Engineers Comments Regarding Surface Water Drainage

Application Reference:	P/36/26/DOC	Reviewer Reference:	EXT2/02
Planning Officer:	Hannah Kersley	Date of Review:	29/09/26
Site Name:	Land North of Sefter Road & 80 Rose Green Road Pagham		
Application Description:	Approval of details reserved by condition under P/134/16/OUT as amended by P/34/25/NMA relating to condition 13B- Surface Water Drainage.		
Assessment Number:	2

Application Reference: P/36/26/DOC Site Name: Land North of Sefter Road & 80 Rose Green Road Pagham	Initial Issue Date: 02/06/2026 Issue Date: 29/09/2026 Reviewer Reference: EXT2
--	--

Drawing Title: As Built Storm
Water Drainage Survey -
Regis Park, Sefter Road,
Pagham, Bognor Regis, PO21
3EE - SHEET 2.

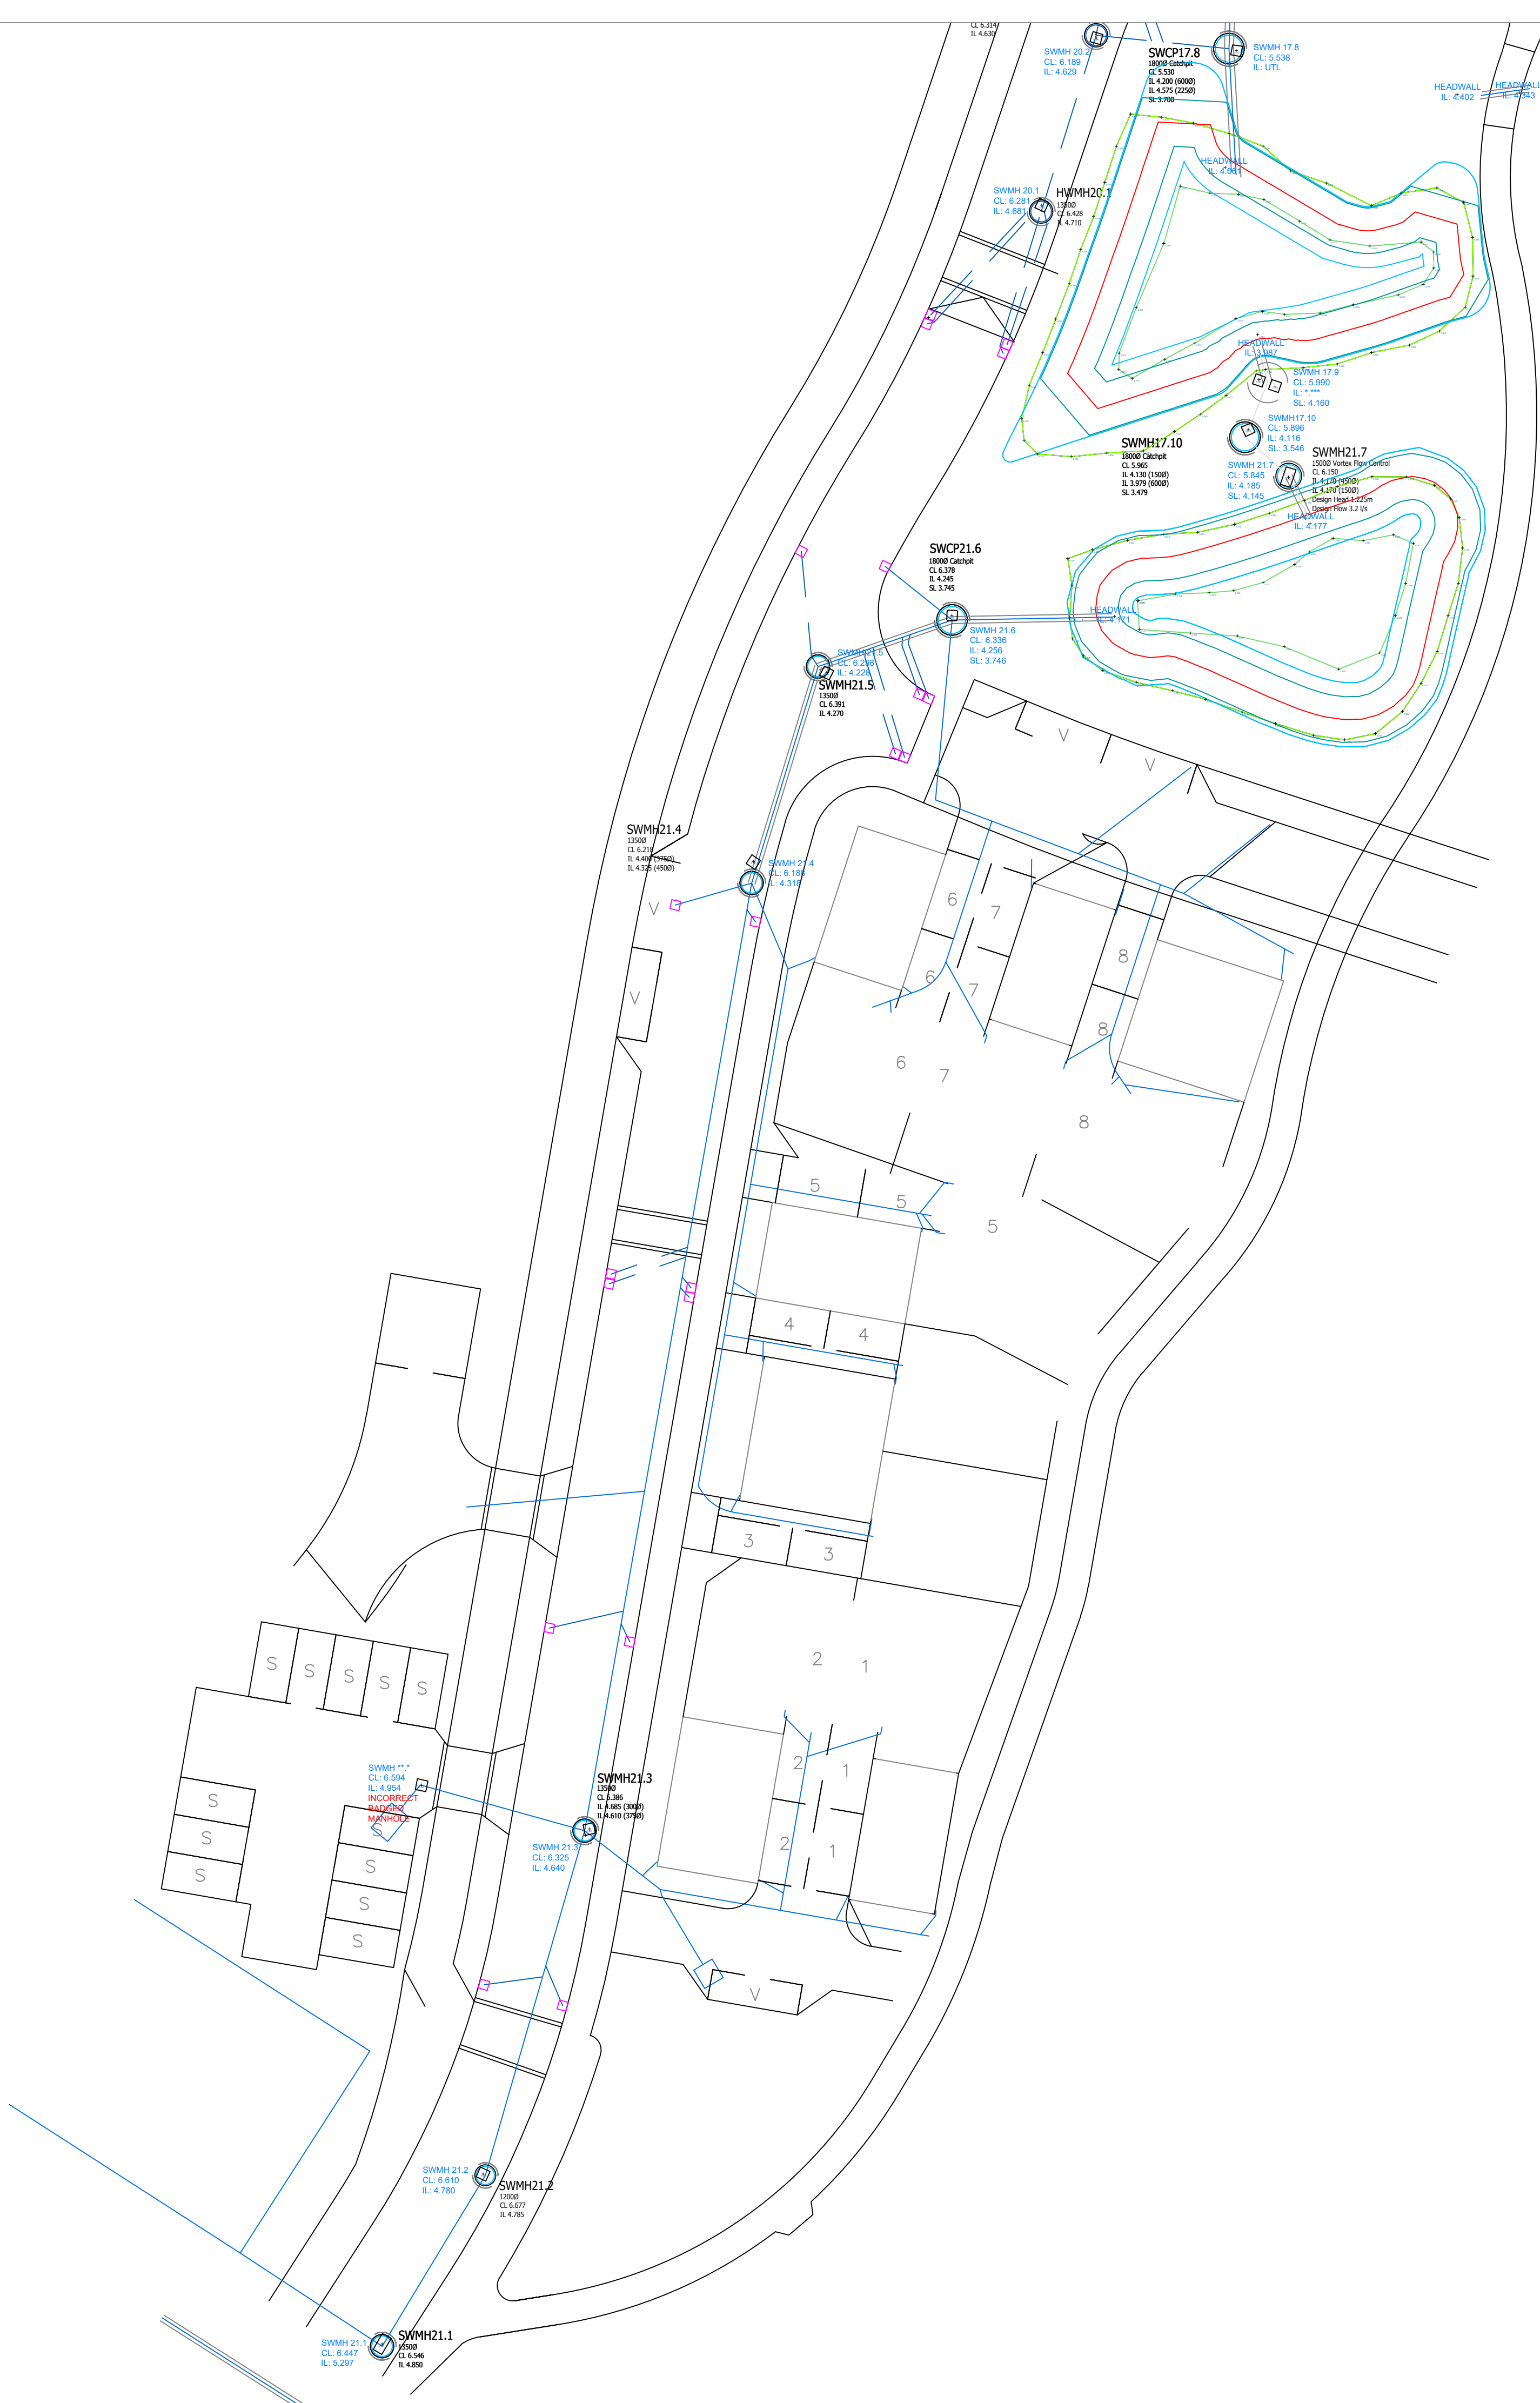
8.	Verification Report Contents: "As built' Survey with drawings of suitable scaling, to include all relevant details discussed below" The as built survey is incomplete as it is missing information for some chambers and no levels are provided for the basins.	Bottom of basin levels now surveyed and included within the as-built of the revised report. Pages 193 and 194.	Noted. Commented closed.

9.	Verification Report Contents: "Commentary comparing the 'as-built' survey with the approved plans. This includes ground levels and pipe/structure levels." The as built drawing confirm that some pipe invert levels are not as designed, this is not discussed in the report.	Refer to point 4.2.3 and 4.2.4 within the verification report.	Noted. Commented closed.

15.	As-Built Drawings and Topographic Survey Pipe diameters and materials are not shown	Refer to as-built survey. Information added.	This does not appear to have been updated. Comment outstanding.

17.	As-Built Drawings and Topographic Survey Tank base levels, height, cover level and plan dimensions are not shown.	As per comment 10, delivery note included for the one attenuation tank onsite to evidence compliance with approved drawing. Unable to survey at this stage as installed a number of years ago prior to ADC SuDS guidance requiring installation to be documented.	Noted. Further evidence is required to conclude install to the design. Comment outstanding.
